**WELWYN HATFIELD BOROUGH COUNCIL
EXECUTIVE DIRECTOR - PLANNING, PUBLIC PROTECTION AND GOVERNANCE**

Application No: 6/2018/2824/HOUSE
Location: 107 Eddington Crescent Welwyn Garden City AL7 4SX
Proposal: Erection of single storey front extension to existing garage to facilitate conversion of garage & part single part two storey rear extension following demolition of existing conservatory & alterations to openings
Officer: Ms Louise Sahlke

Recommendation: Refused

Drawing No: 4533-P01-DIM Revision:

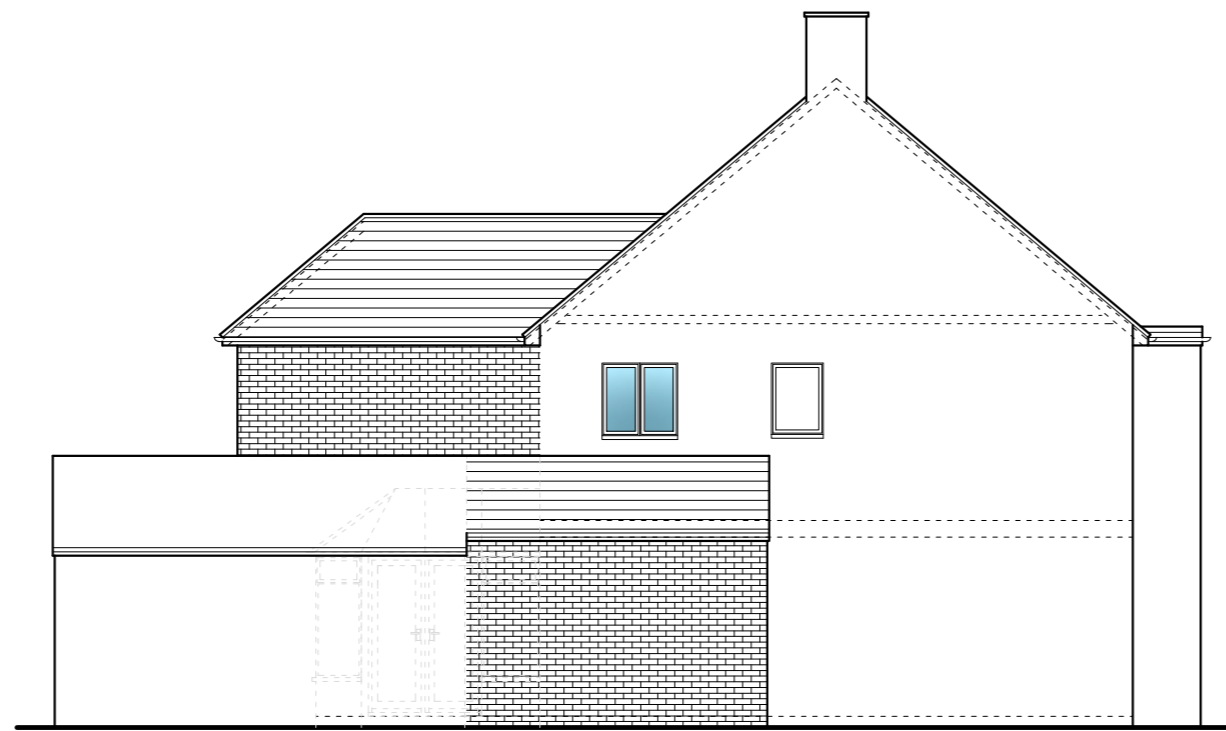
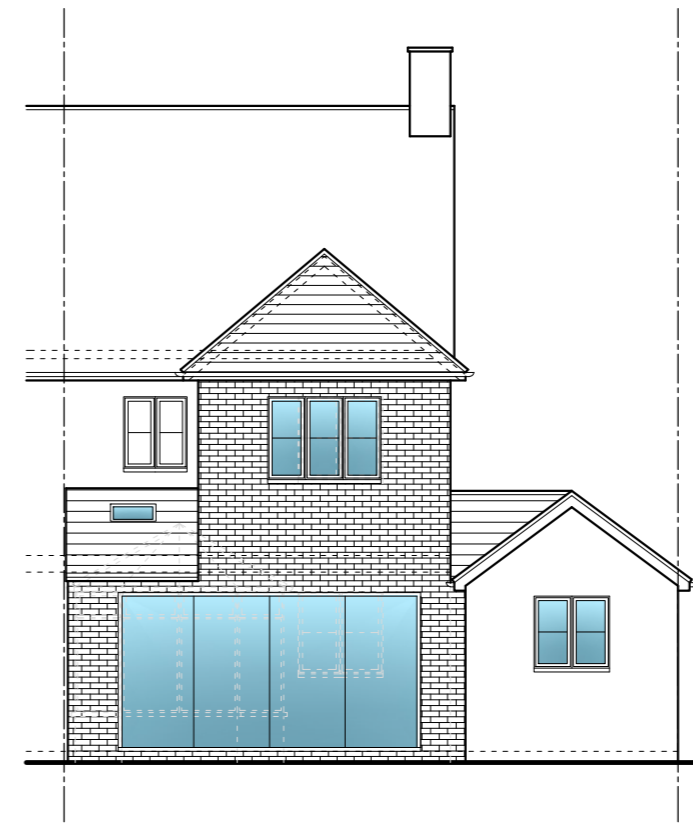
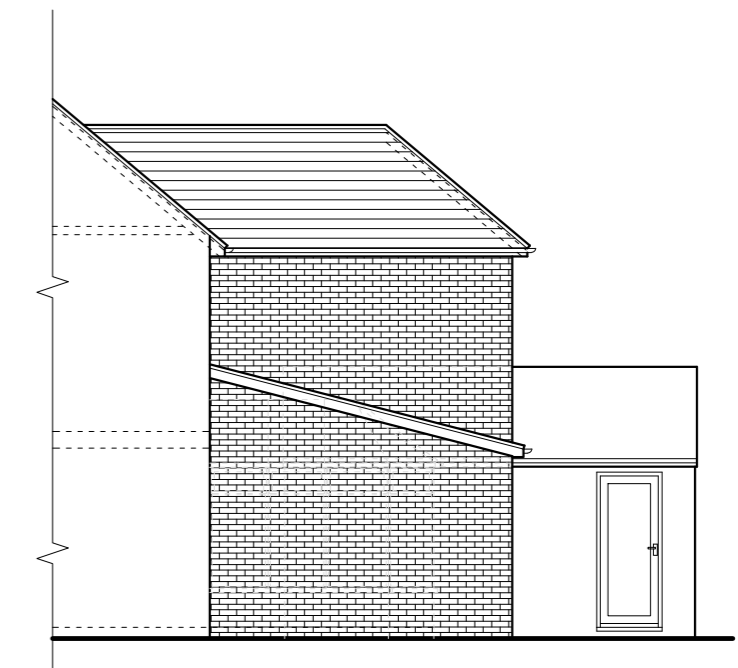
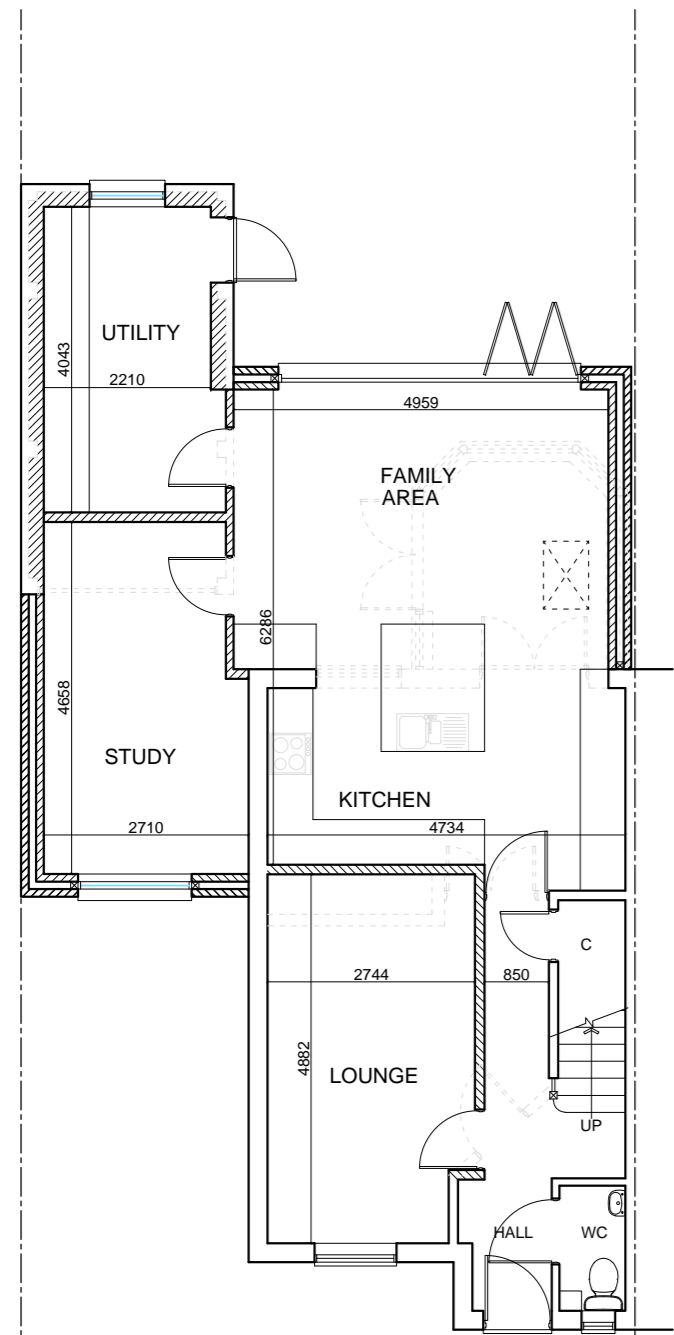
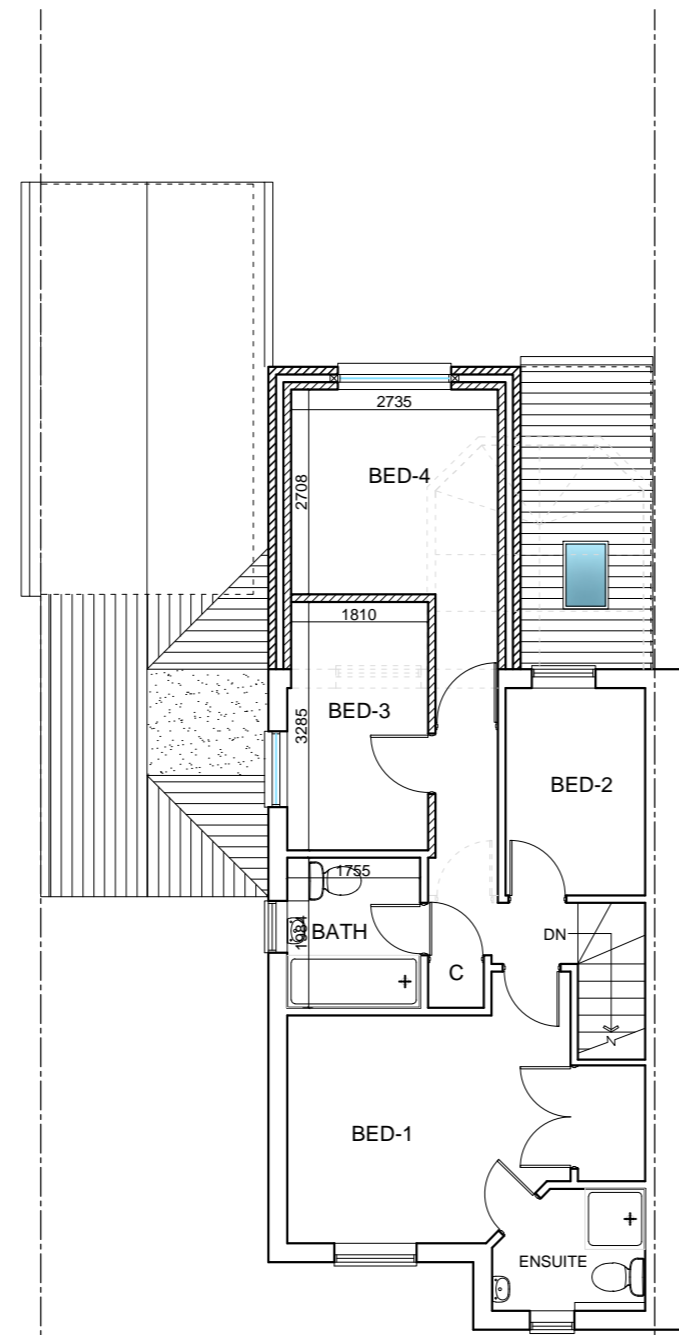
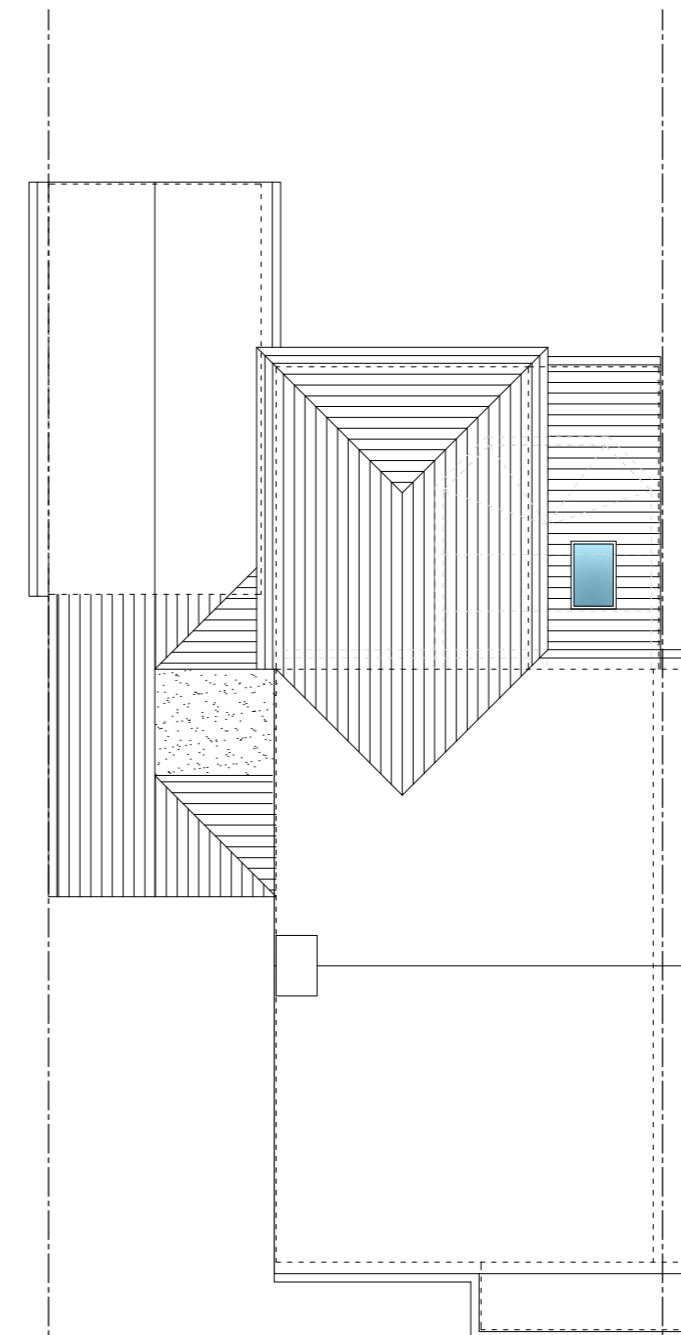
| <p>Impact on neighbours</p> | <p><i>Loss of privacy</i></p> <p>The proposal introduces a first floor flank window which serves bedroom 3. This window is clear and openable. This window is approximately 12 metres away from the rear elevation of the row terraces (97-105 Eddington Crescent) and approximately 3 metres away from the rear boundary line of the small rear gardens of these properties. It should be noted that the most direct relationship is with 99 and 101 Eddington Crescent. The privacy of these neighbours would</p> |

be greatly limited and oppressive by virtue of the close proximity and direct relationship with this clearly glazed, main habitable window. Therefore the proposal would result in a detrimental loss of privacy and overlooking to the rear elevation which includes main habitable windows and doors and all of the small rear gardens of 97-105 Eddington Crescent with the most affected properties being 99-101 Eddington Crescent. Accordingly, the proposal would be contrary to the provisions of the National Planning Policy Framework 2018, Policies D1 and D2 of the District Plan 2005, and Supplementary Design Guidance 2005 in this instance.

The proposed first floor rear window would introduce oblique angles of the rear elevations and gardens of neighbouring properties. Although the level of projection of this window is greater than the existing rear wall, it is considered that the relationship with neighbouring properties in regards to oblique views of their rear elevations and gardens remains the same as the existing rear windows. Therefore is considered acceptable.

It is not considered that the conversion of the garage and single storey front extension would result in a loss of daylight, sunlight or overdominance This is because although the front extension is located on the boundary line of 97-101 Eddington Crescent and would be higher than the existing boundary treatment, it is single storey in height with a pitched roof reducing the bulk away from boundary line. Therefore although there is some impact on the outlook of the ground floor windows of 97-101 Eddington Crescent, the impact is not significant to result in a reason for refusal. It is not considered that the single storey front extension would result in a loss of daylight, sunlight, or overdominance to these properties.

| | <p>There is currently a light weight conservatory located on the boundary line with 109 Eddington Crescent. Therefore it is not considered that there is currently an impact on this neighbour. This neighbour does not have a rear extension and has a main habitable room adjacent to the boundary line with 107 Eddington Crescent.</p> <p>The proposed rear extension by virtue of its excessive height, width and depth combined with its proximity to the neighbouring property's rear boundary line and main habitable rear windows and doors would appear unduly overbearing and would result in a loss of outlook, daylight and sunlight to the rear of 109 Eddington Crescent and respective garden. Therefore would have a detrimental impact on their residential amenity. Accordingly, the proposal is contrary to the provisions of the National Planning Policy Framework 2018, Policies D1 and D2 of the District Plan 2005, and Supplementary Design Guidance 2005 in this instance.</p> |

1. The privacy of bedroom 3 through the clear and openable window would be greatly limited by virtue of the close proximity and direct relationship with the number of habitable ground and first floor rear facing windows and to a lesser degree rear gardens from the row of terrace (97-105 Eddington Crescent) Therefore the proposed development would not provide satisfactory living conditions for its current and future occupants.

2. The proposed first floor flank window which serves bedroom 3 is clear and openable. This window is approximately 12 metres away from the rear elevation of the row terraces (97-105 Eddington Crescent) and approximately 3 metres away from the rear boundary line of the small rear gardens of these properties. It should be noted that the most direct relationship is with 99 and 101 Eddington Crescent. The privacy of these neighbours would be greatly limited by virtue of the close proximity and direct relationship with this clearly glazed, main habitable window. Therefore the proposal would result in an unacceptable loss of privacy and overlooking to the rear elevations, which includes main habitable windows and doors, and all of the small rear gardens of 97-105 Eddington Crescent with the most affected properties being 99-101 Eddington Crescent. Accordingly, the proposal would be contrary to the provisions of the National Planning Policy Framework 2018, Policies D1 and D2 of the District Plan 2005, and Supplementary Design Guidance 2005.

3. The proposal fails to provide adequate on-site parking to accommodate the proposed development. Accordingly, the proposal fails to comply with Policies D1, D2 and M14 of the Welwyn Hatfield District Plan 2005, the Supplementary Design Guidance 2005, the Supplementary Planning Guidance on Parking Standards 2004 and the National Planning Policy Framework 2018.

4. The proposed part two, part single storey rear extension, in regards to its overall scale, height, width, depth, massing and architectural detailing would fail to be subordinate in scale or appearance to the original dwelling and associated garage resulting in cramped and overly dominant additions which would fail to respect the form and scale of the original dwelling and associated garage. Accordingly, the proposal would represent a poor quality of design and would be contrary to provisions of the National Planning Policy Framework 2018, Policies D1

5. The proposed rear extension by virtue of its excessive height, width and depth combined with its proximity to the neighbouring property's rear boundary line and main habitable rear windows and doors would appear unduly overbearing and would result in a loss of outlook, daylight and sunlight to the rear of 109 Eddington Crescent and respective gardens. It would therefore have a detrimental impact on their residential amenity. Accordingly, the proposal is contrary to the provisions of the National Planning Policy Framework 2018, Policies D1 and D2 of the District Plan 2005, and Supplementary Design Guidance 2005 in this instance.
